Your Ref: OWPC5243
Our Ref: EP/17/15/HH 11-02-2015
Please ask for:
Mr D Easton

Front, side & rear extensions (resubmission following EP/112/14/HH).
19 Selborne Way East Preston

DRAWING TITLE
PROPOSED FLOOR PLANS

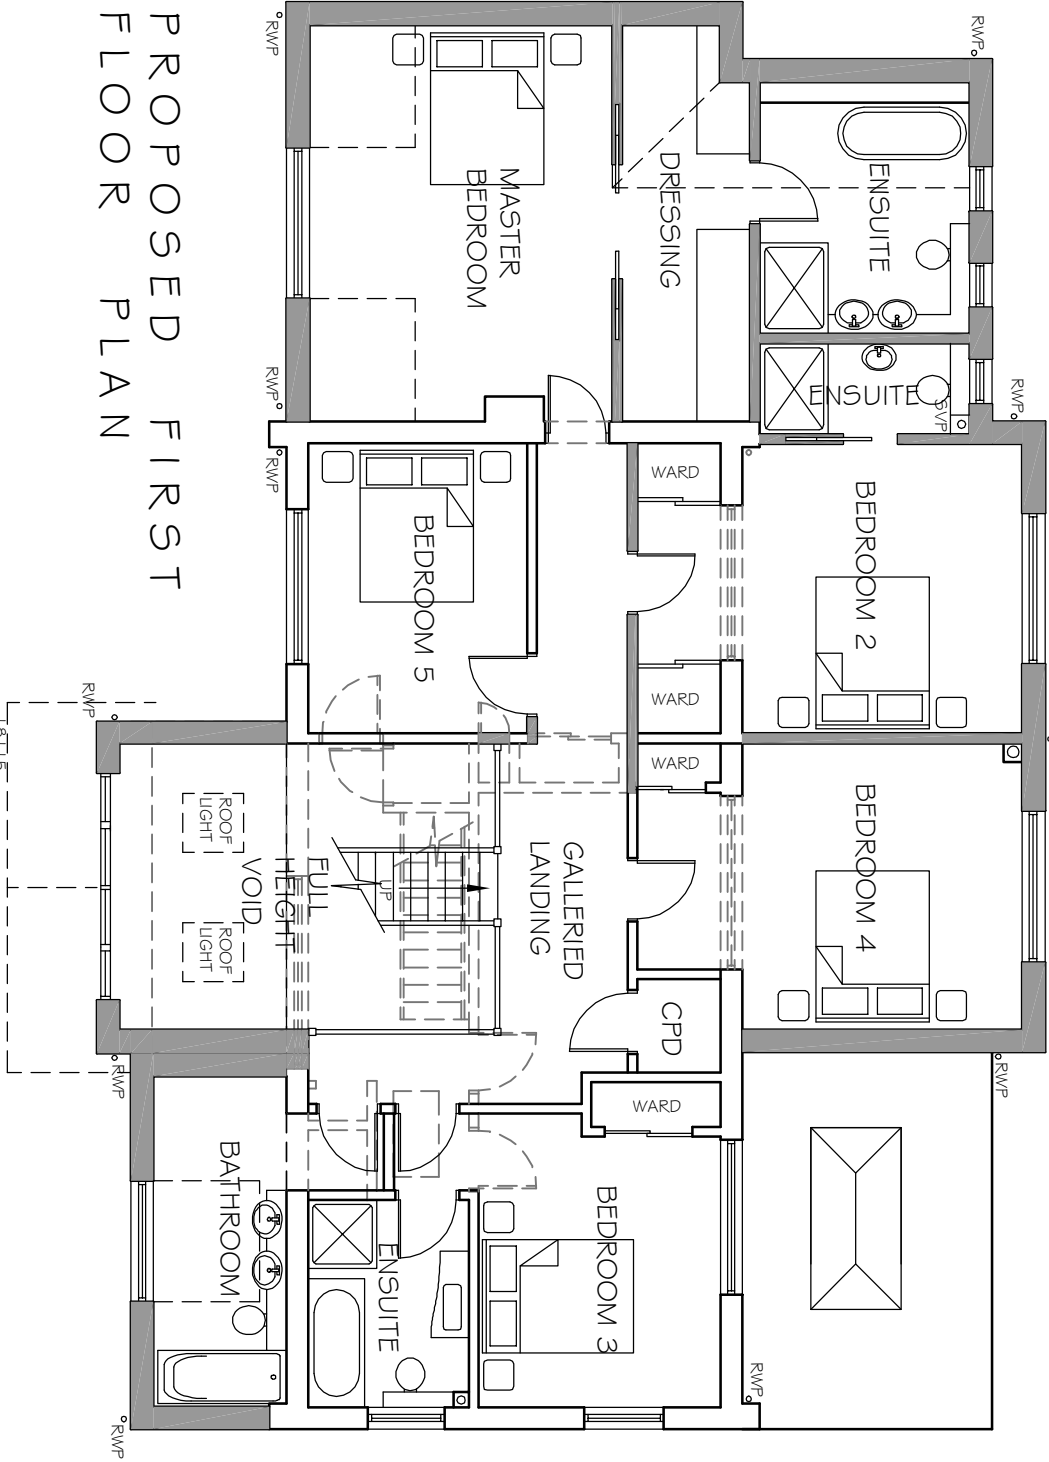
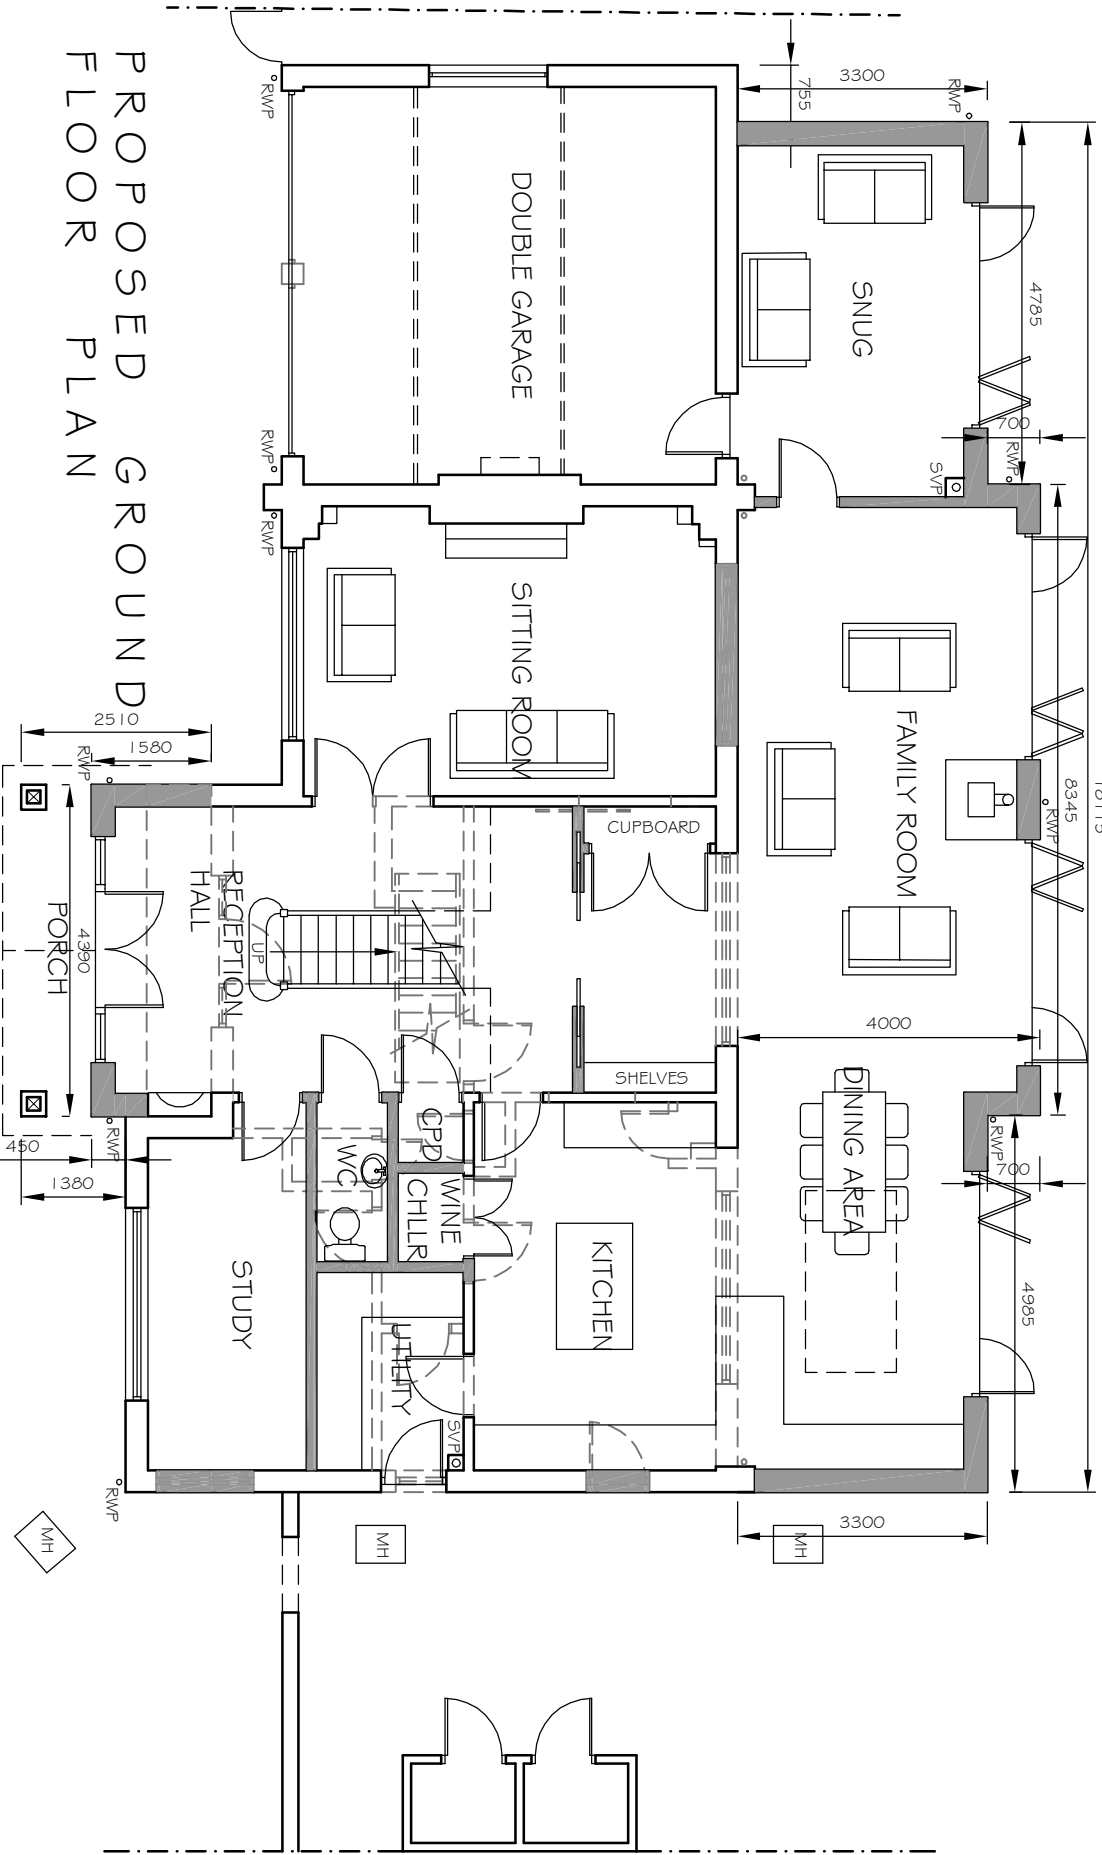
I have great affection for the area and again object to this planning application. The development is not in keeping with the other properties in the road and is largely out of scale from the current building. Our main concern is the size and height of the side extension and how close it will be to the boundary line. I believe it would be too overbearing. It would be a great shame to change the look of the road which has always enjoyed a high standard with a similar theme, where properties are in keeping with one another. We feel the development would be out of character with its neighbours. My father is a keen amateur astronomer who also objects to the over use of large glazing and skylights which will add further light pollution to our nights skylight.
